FW: P/5/26/PL

I'm just about to head on site and post the notices for this application, but in reviewing the description and given the size of the rear dormer proposed to the existing bungalow, I think it is worth including a specific reference to the inclusion of the dormer extension within the description and on the notices to be posted.

'1 No 4-bed chalet bungalow, alteration of existing bungalow to include off-street parking and rear dormer extension (resubmission following P/118/25/PL). This application is in CIL Zone 4 and is CIL Liable as a new dwelling.'

Proposed North Elevation 44A

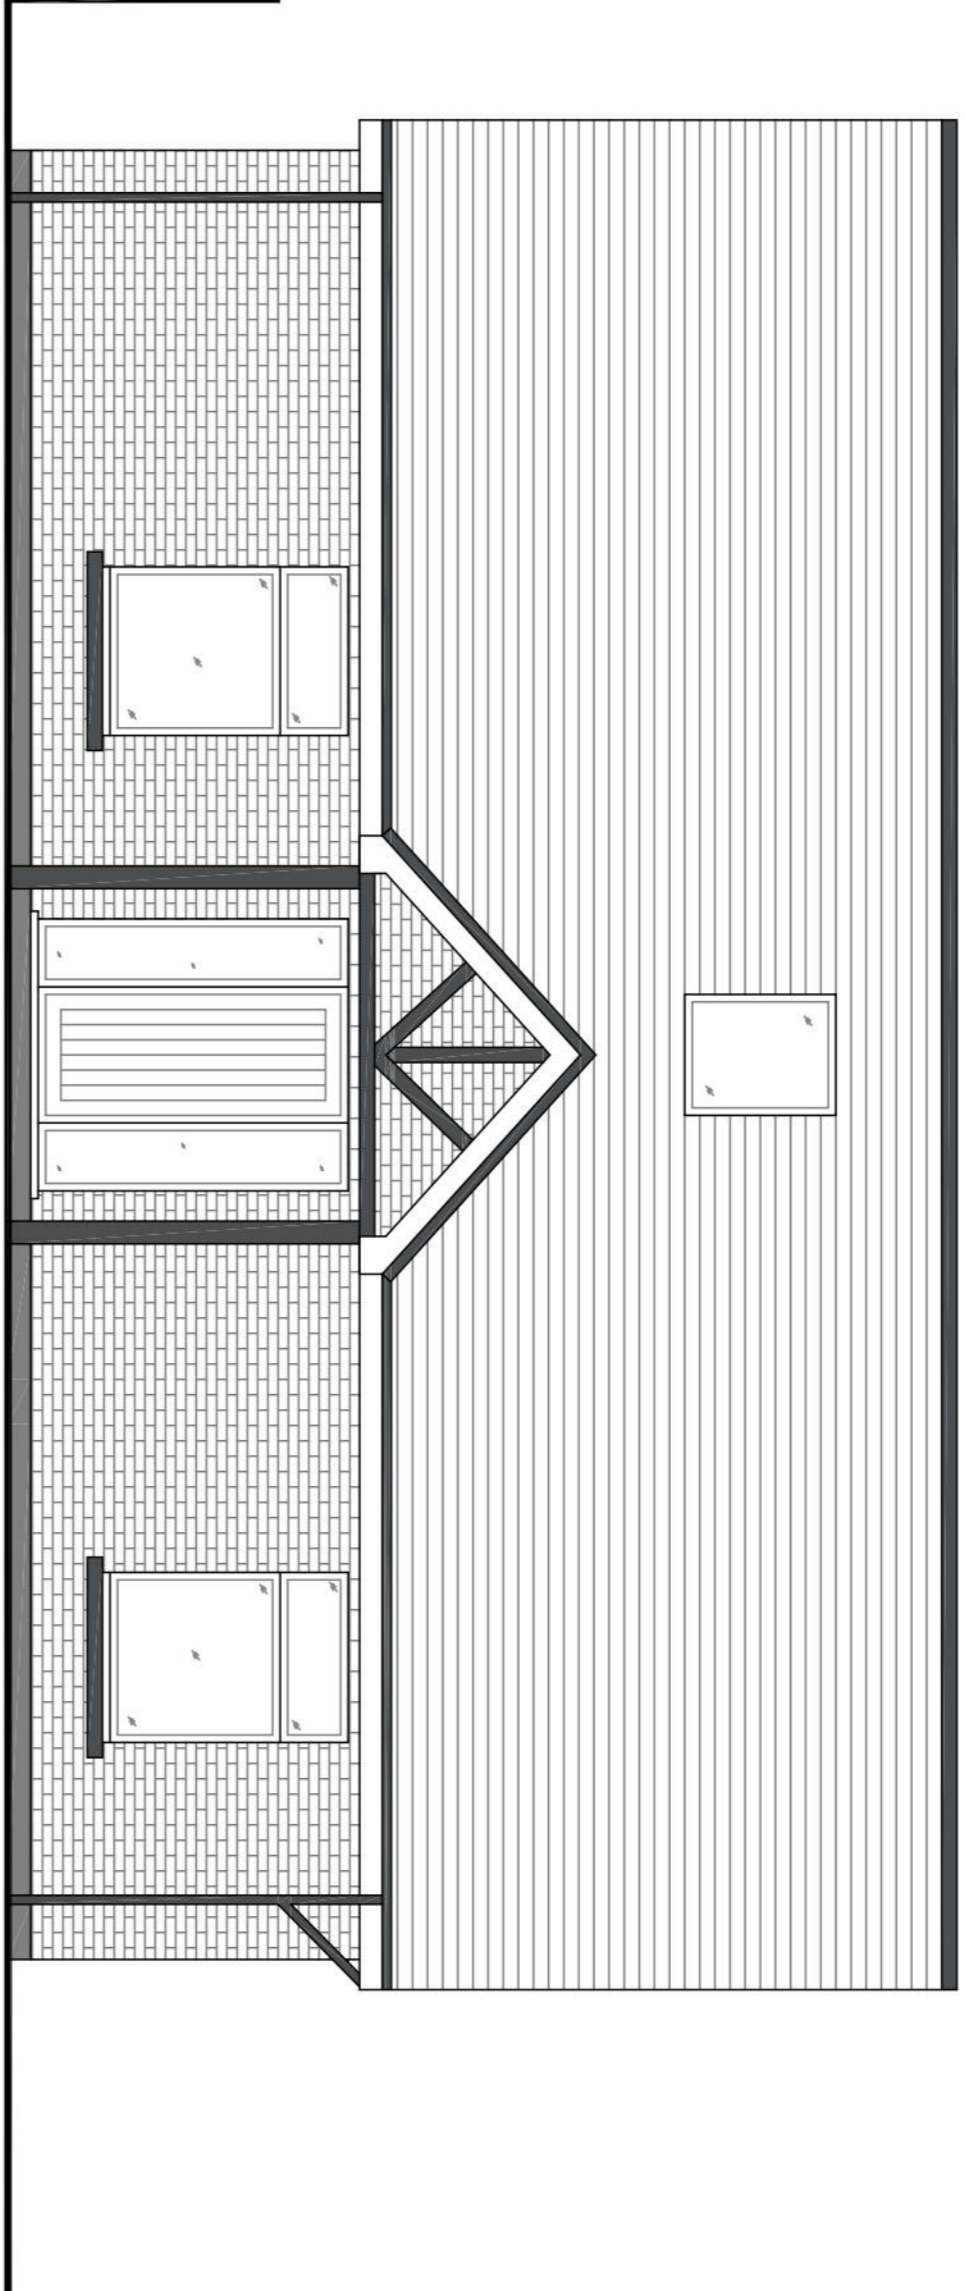
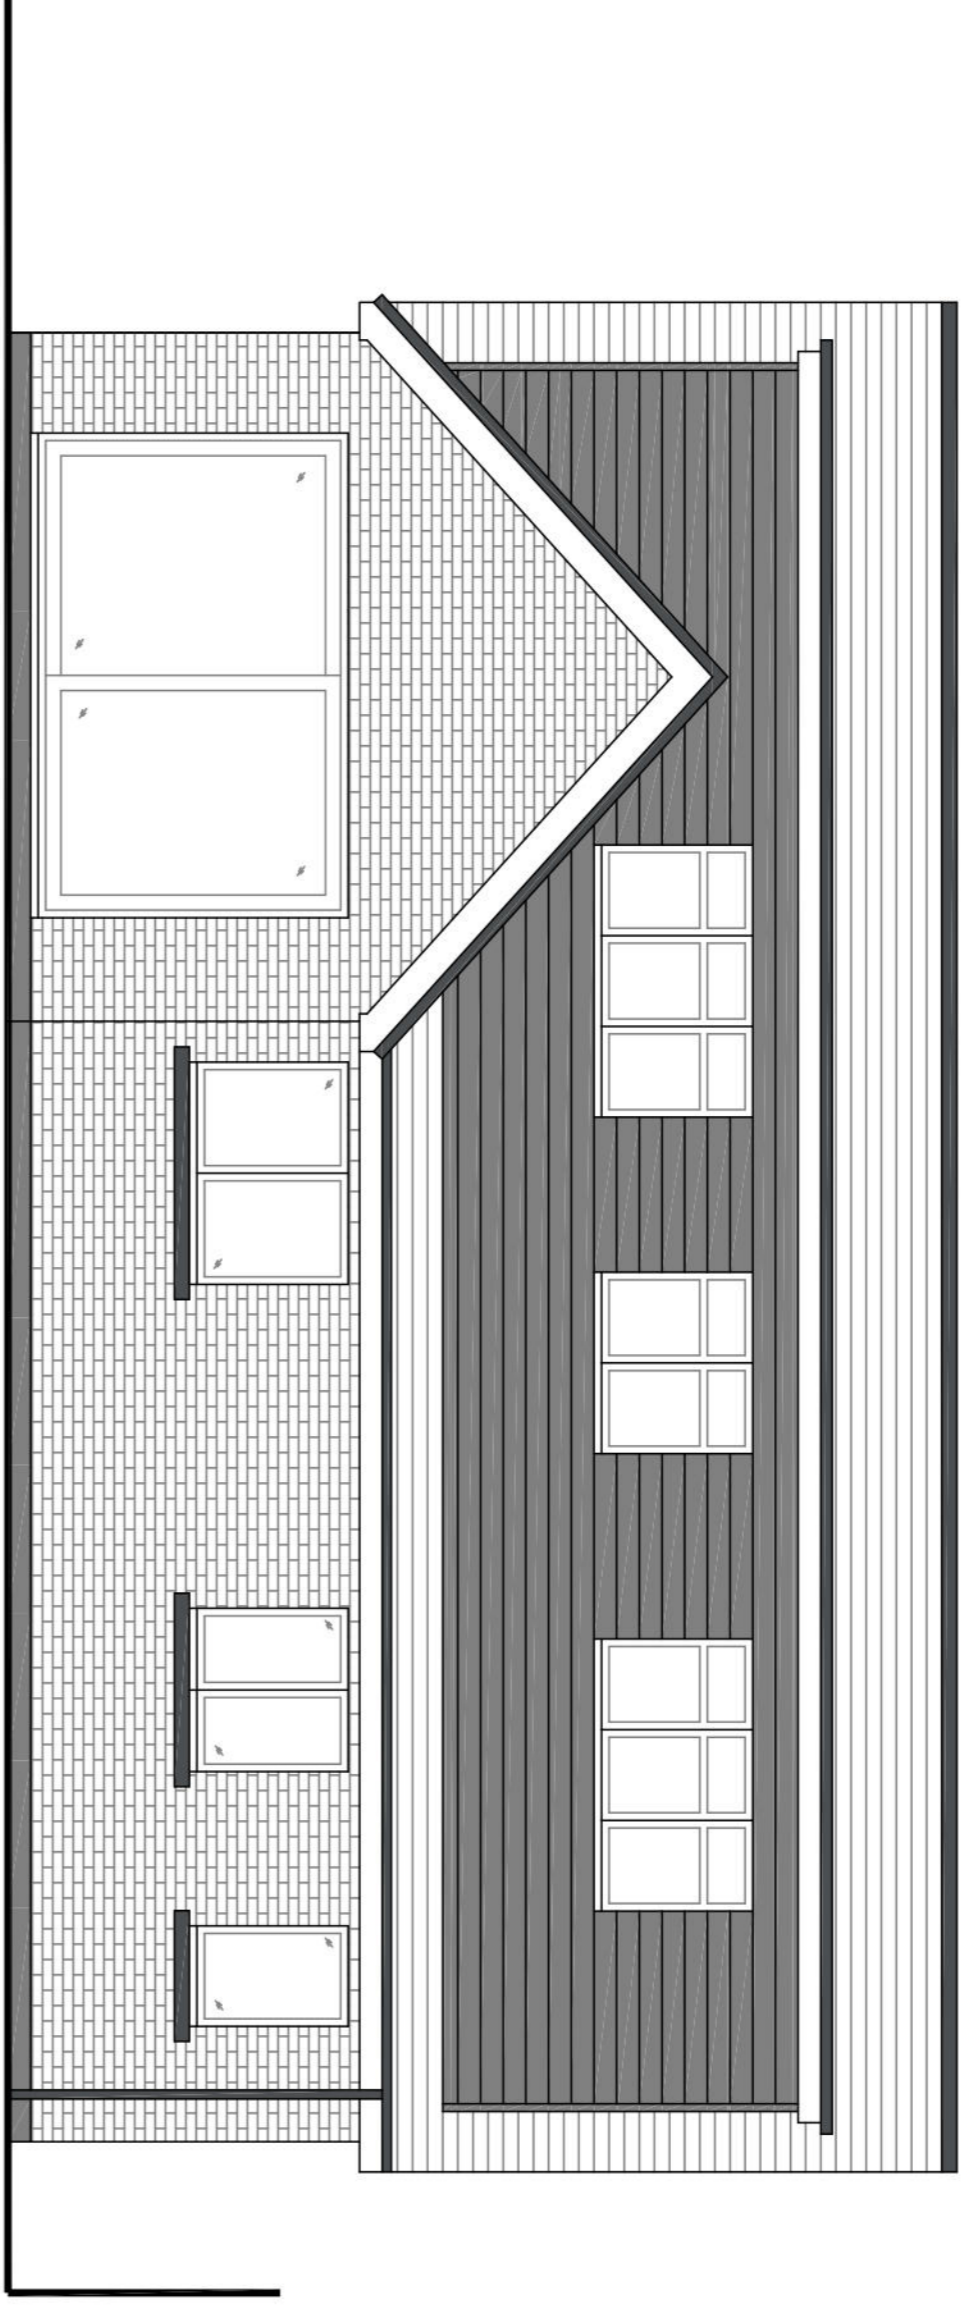
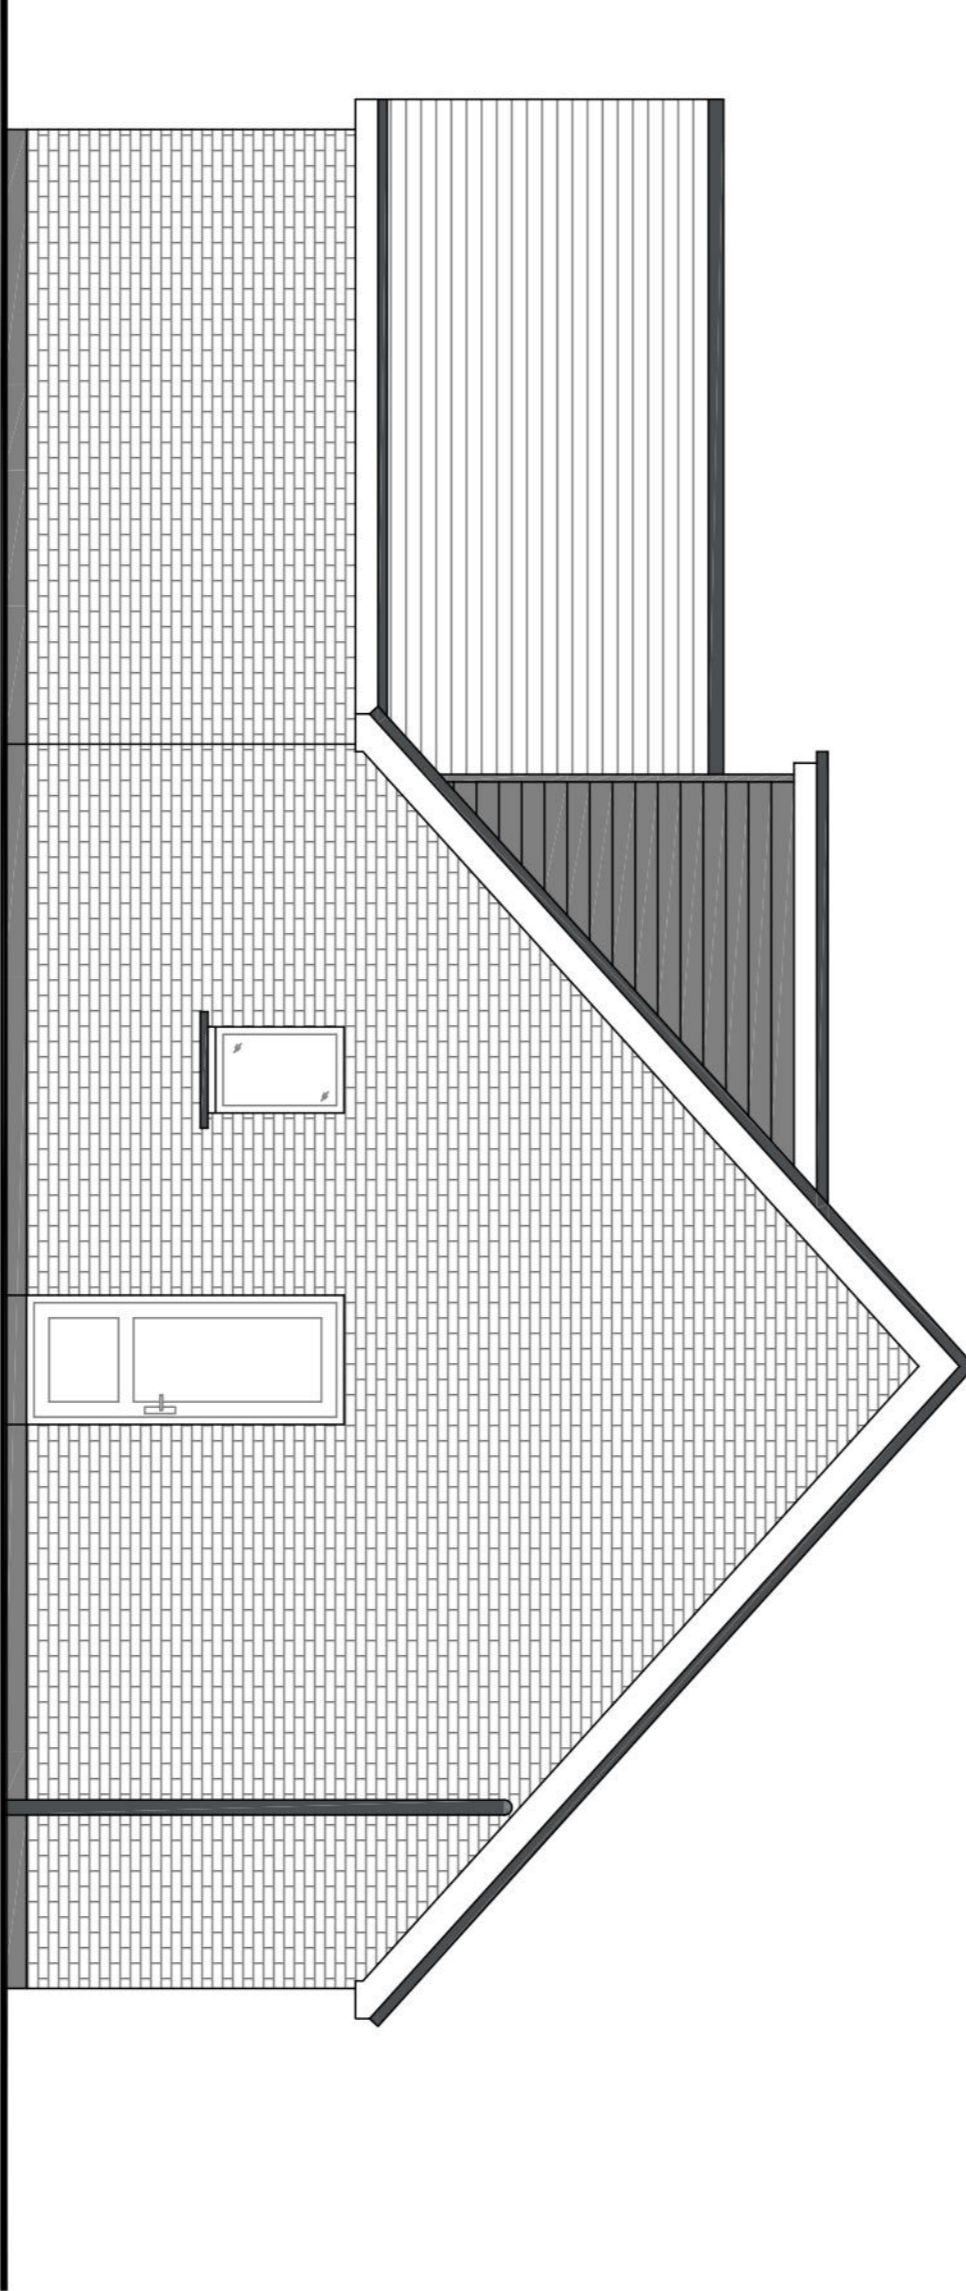
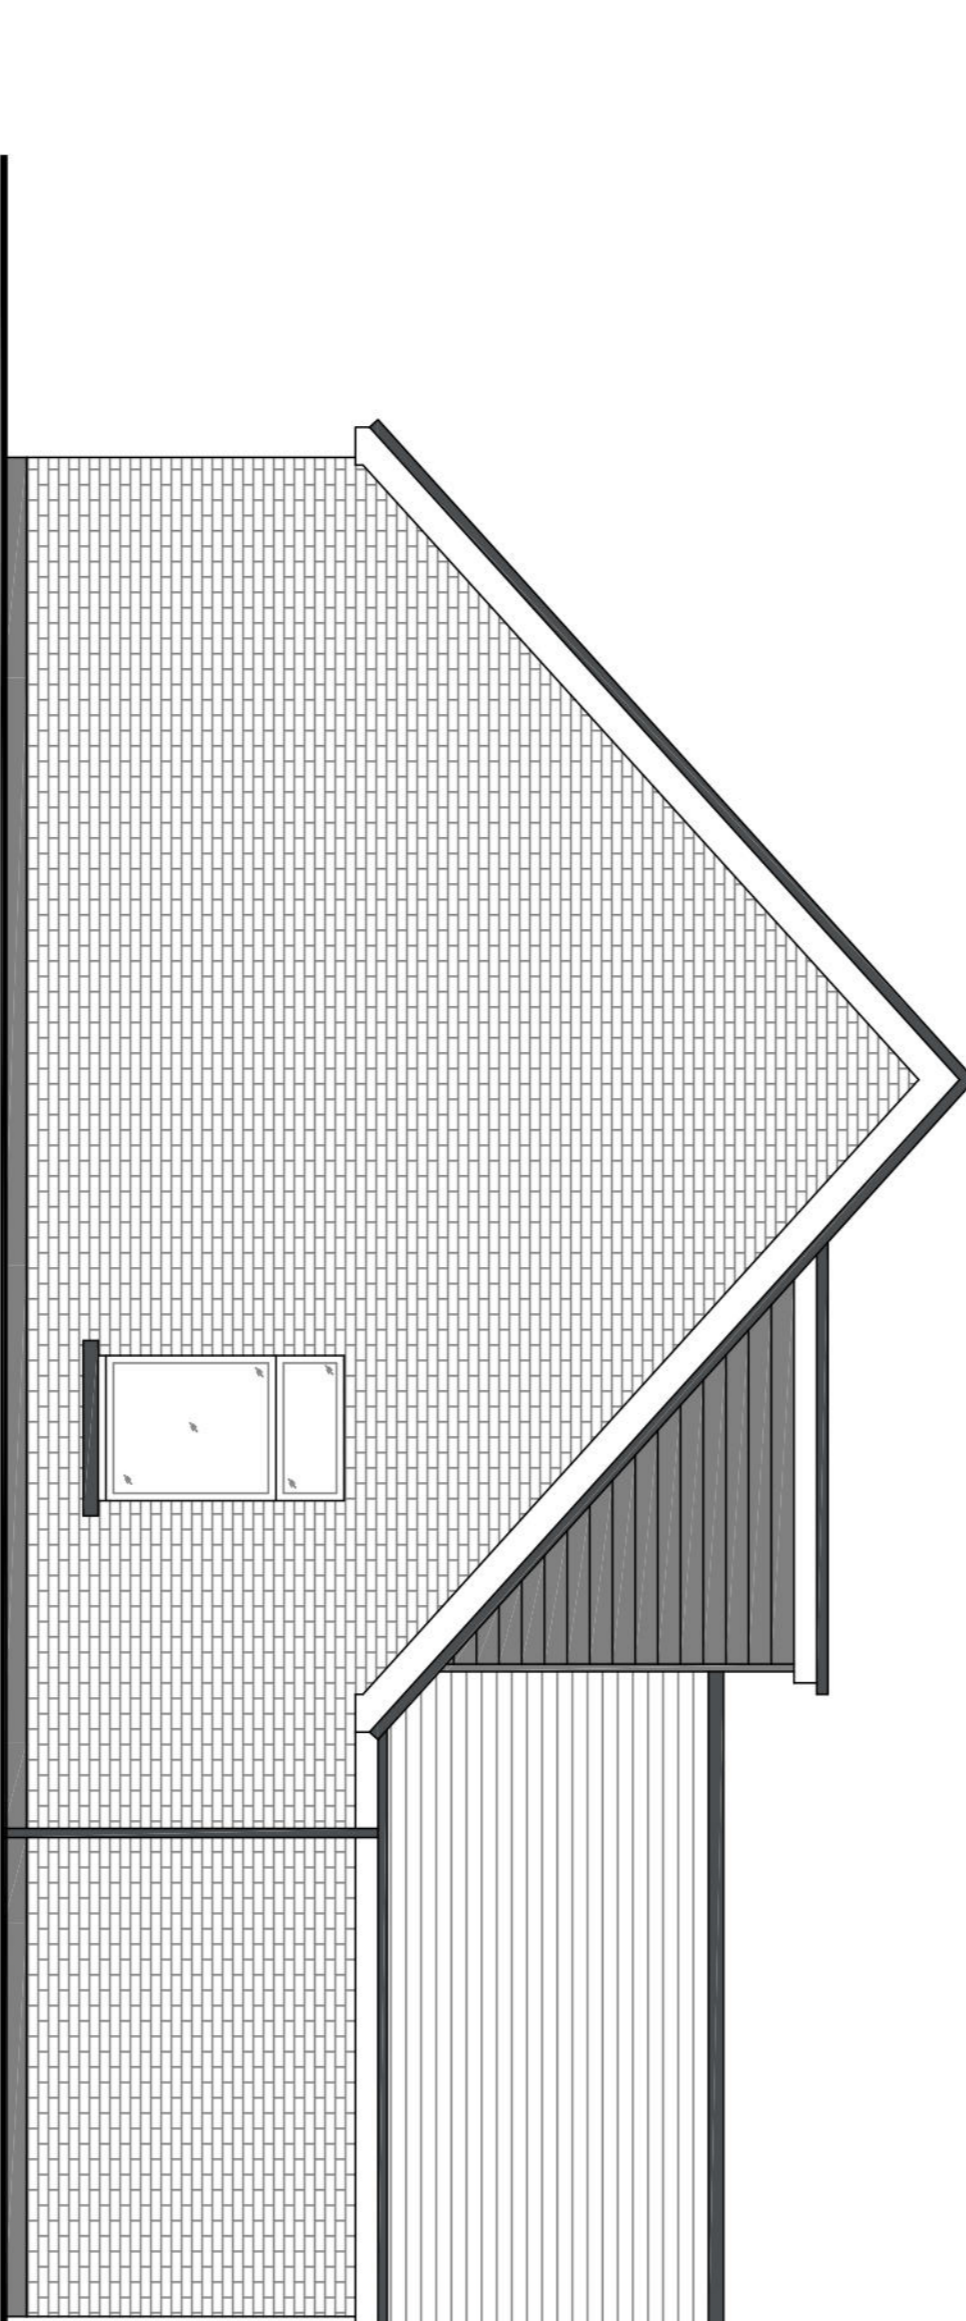
Following review, could I request that the rear dormers of both dwellings are reduced in width, perhaps at least by 0.5m each side, and that they are set back into the roof slope slightly further by perhaps a couple of rows of tiles. Our aim is to reduce their dominance of the rear roof slopes.

Could I also request that the northernmost first-floor rear window within the dormer of No. 44A be reduced to a two-pane casement? With the new design and relocation of the single-storey component, there is a greater perceived and actual overlooking impact of No. 2 Sea Way. The aim of this is to reduce how imposing this viewpoint may feel within the eastern end of No.2's plot, acknowledging that the eastern end of that plot is not the primary amenity space, but still remains of amenity value to the property.
